# CITY OF ALBUQUERQUE

**Re: A & S Autocare**  
4900 2<sup>nd</sup> St. NW Albuquerque NM 87120  
**Traffic Circulation Layout**  
Engineer's/Architect's Stamp **01-15-2020** (F15D054)

Based upon the information provided in your submittal received 01-17-2020, the above referenced plan cannot be approved for Building Permit until the following comments are addressed:

SITE PLAN

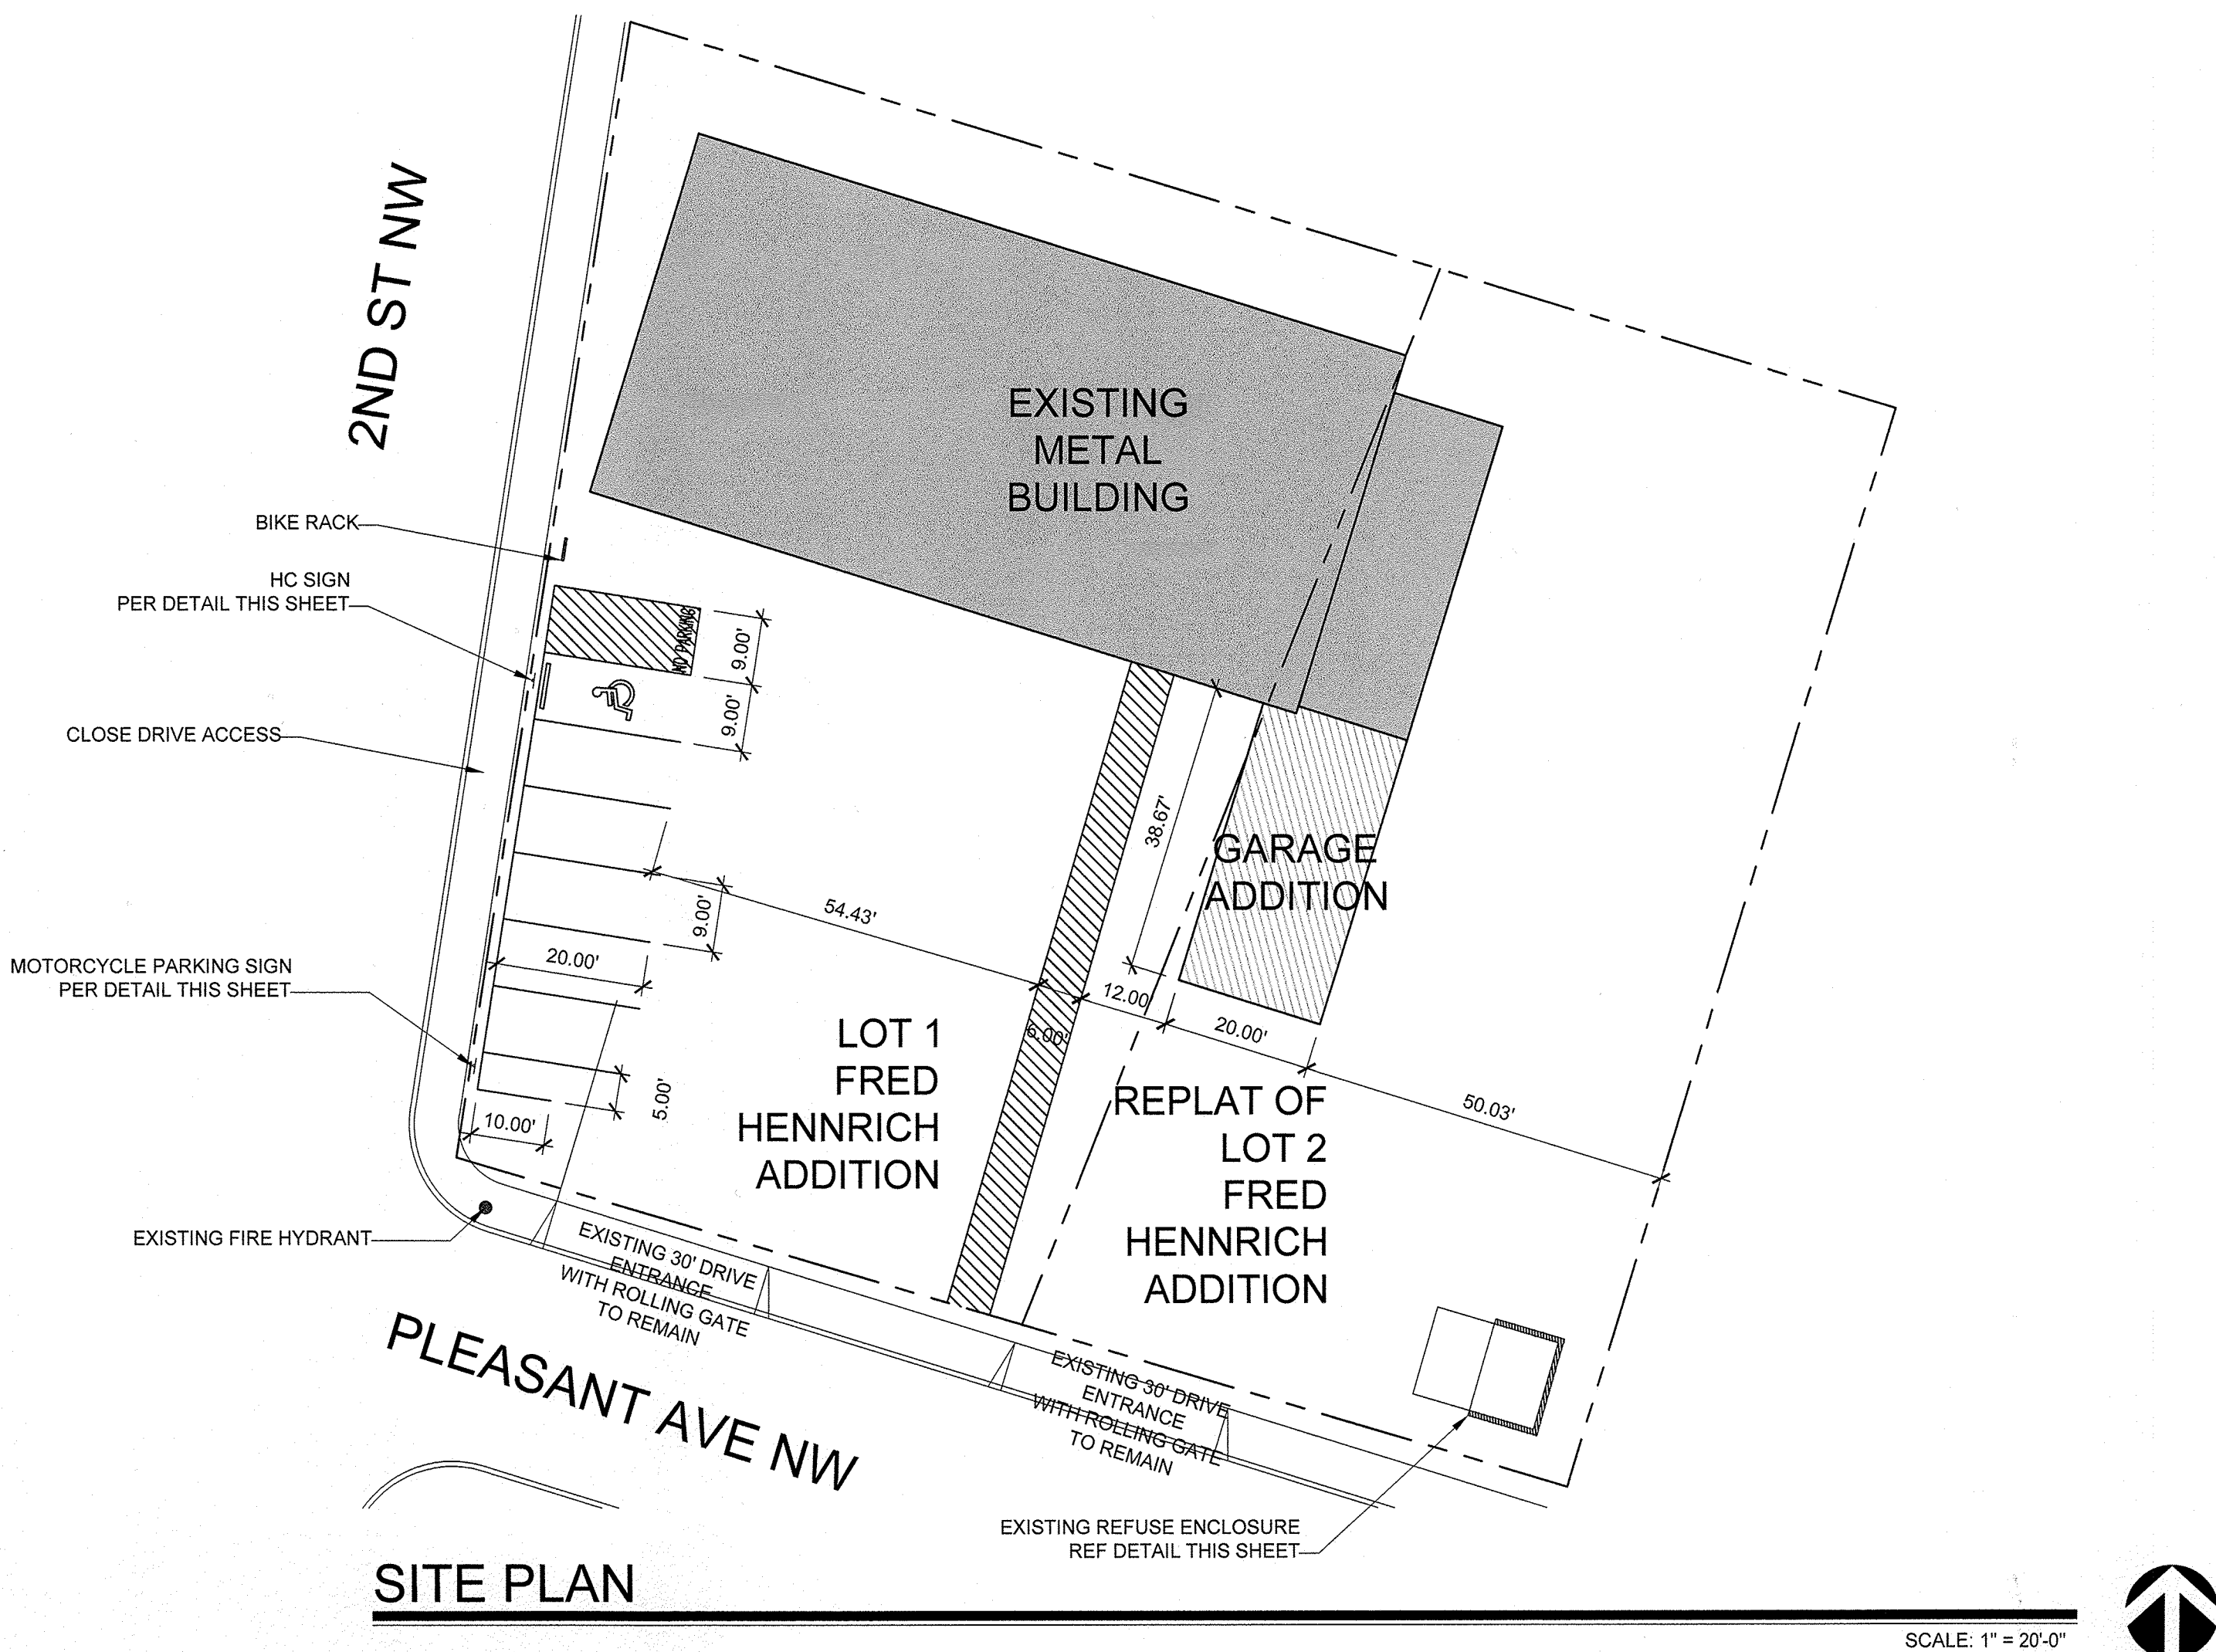
1. It seems like the lot line won't be eliminated. In that case, please provide a shared access agreement.
2. Any unused curb-cut needs to be closed. And there is one on 2<sup>nd</sup> street.
